Hinckley & Bosworth Borough Council
Interested Party Reference Number: 20039546

**REP4 – 121: Doc 18.13 Applicant's response to deadline 3
submissions (part 2 HBBC) – Health**

**Application by Tritax Symmetry (Hinckley) Limited for an
Order Granting Development Consent for the Hinckley
National Rail Freight Interchange**

(ref. TR050007)

Fig 17. Illustrative Public rights of Way

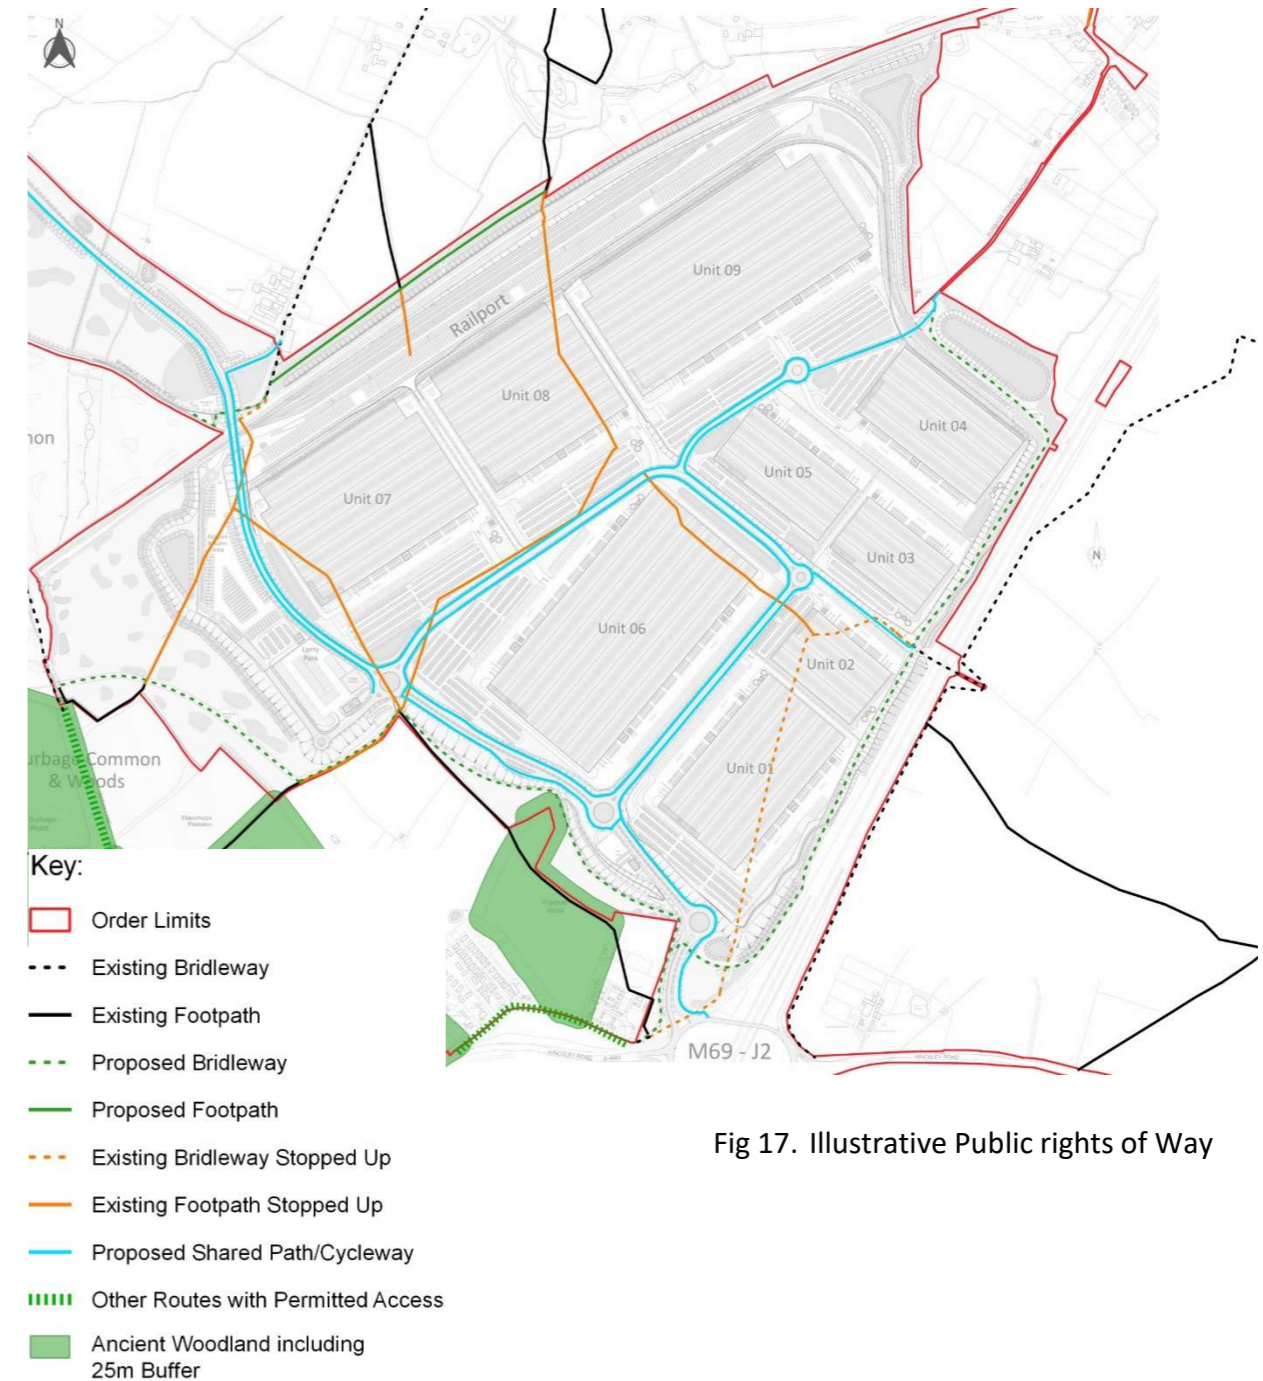
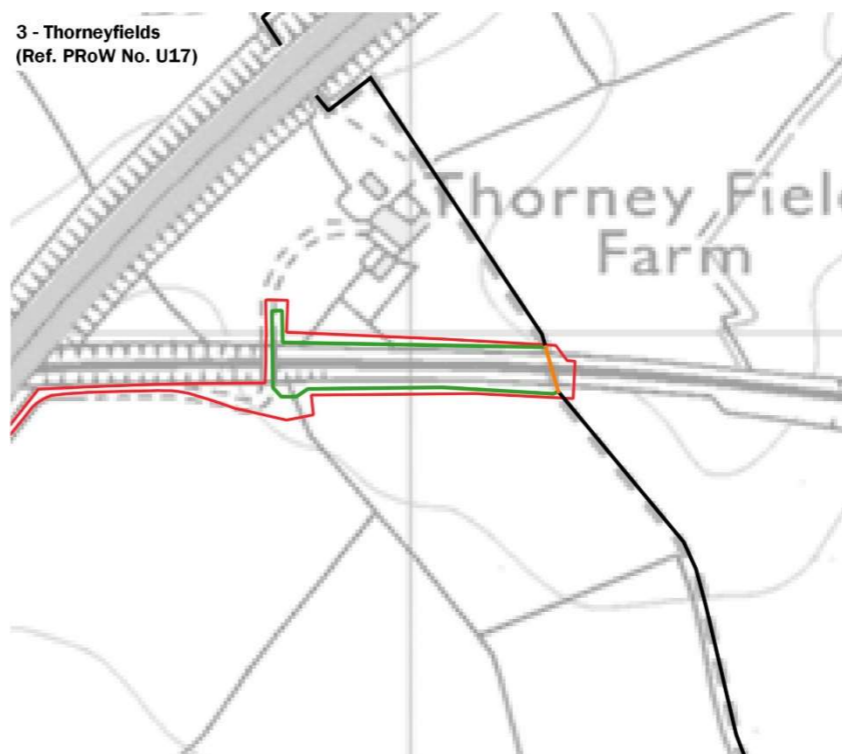
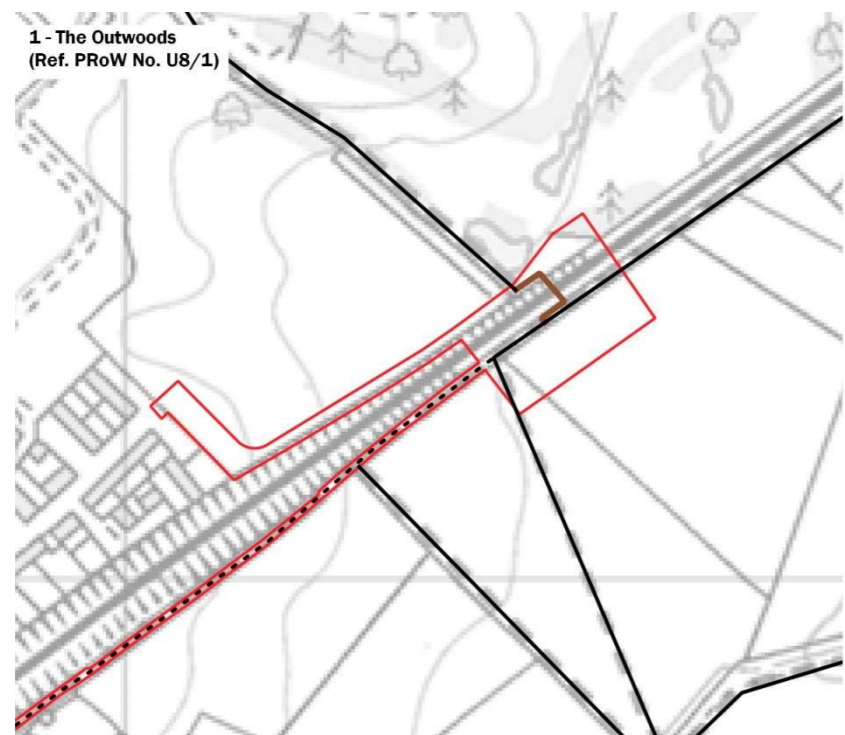
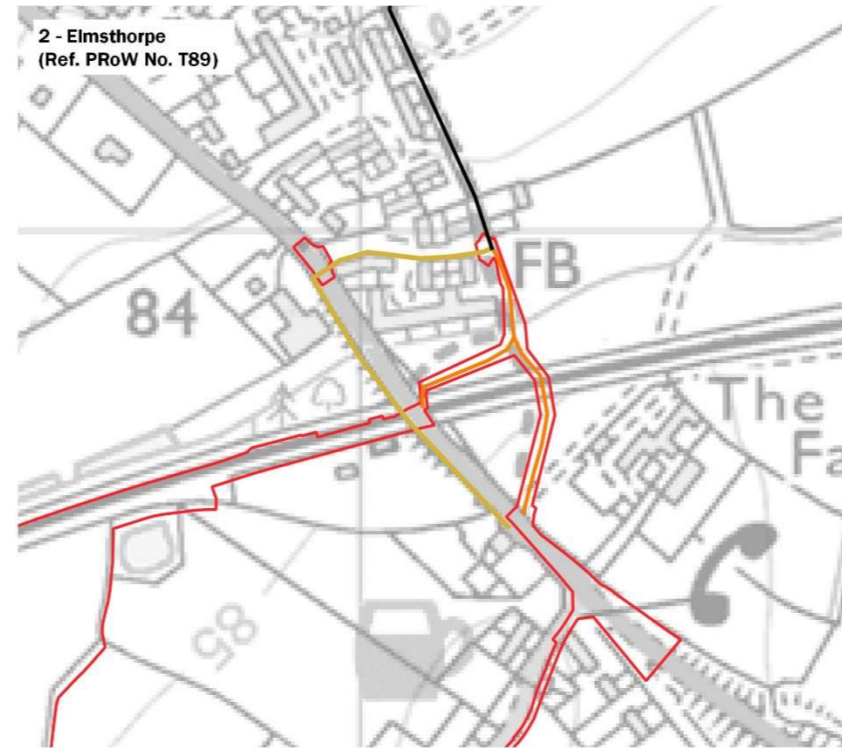
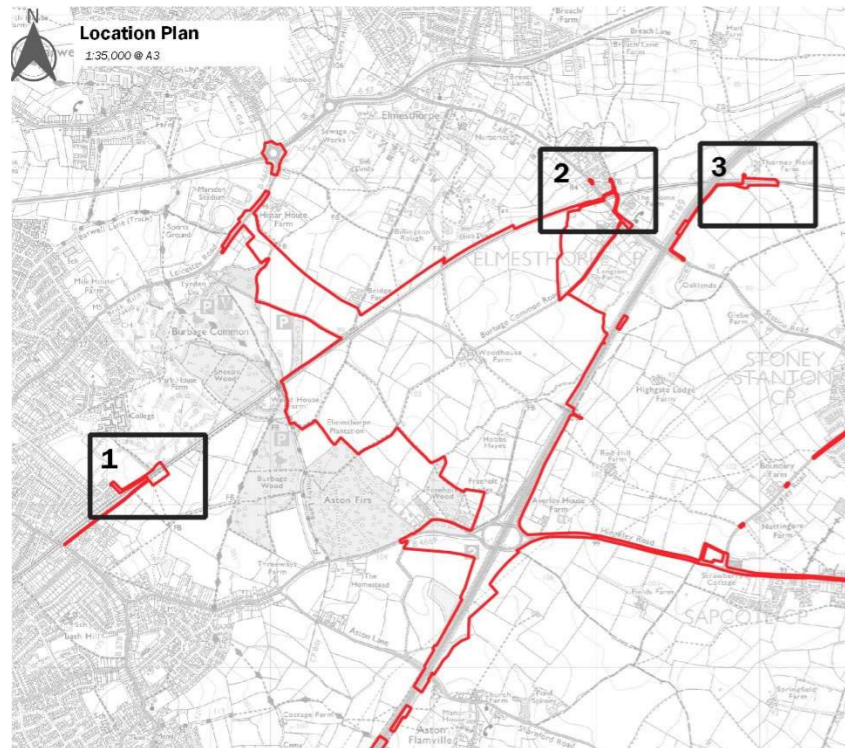
Document and Section Reference	Hinckley & Bosworth Borough Council Response
REP4 - 121 – Response to deadline 3 submission (part 2 HBBC)	
Point 21 – Health	This point has been agreed in the latest SoCG. However, in respect of 7.1. Improved Mental Health: consideration is only given to the provision of net additional long-term employment and the working environment for employees. It does not consider the impacts associated with noise, vibration and landscape and visual effects which are all known to affect mental health.
Point 23 - Health	Further clarification is required as to how good quality open space will be achieved. The LEMP document describes habitat creation/enhancement and does not provide an understanding of how the open spaces will be accessed by the public and well maintained..
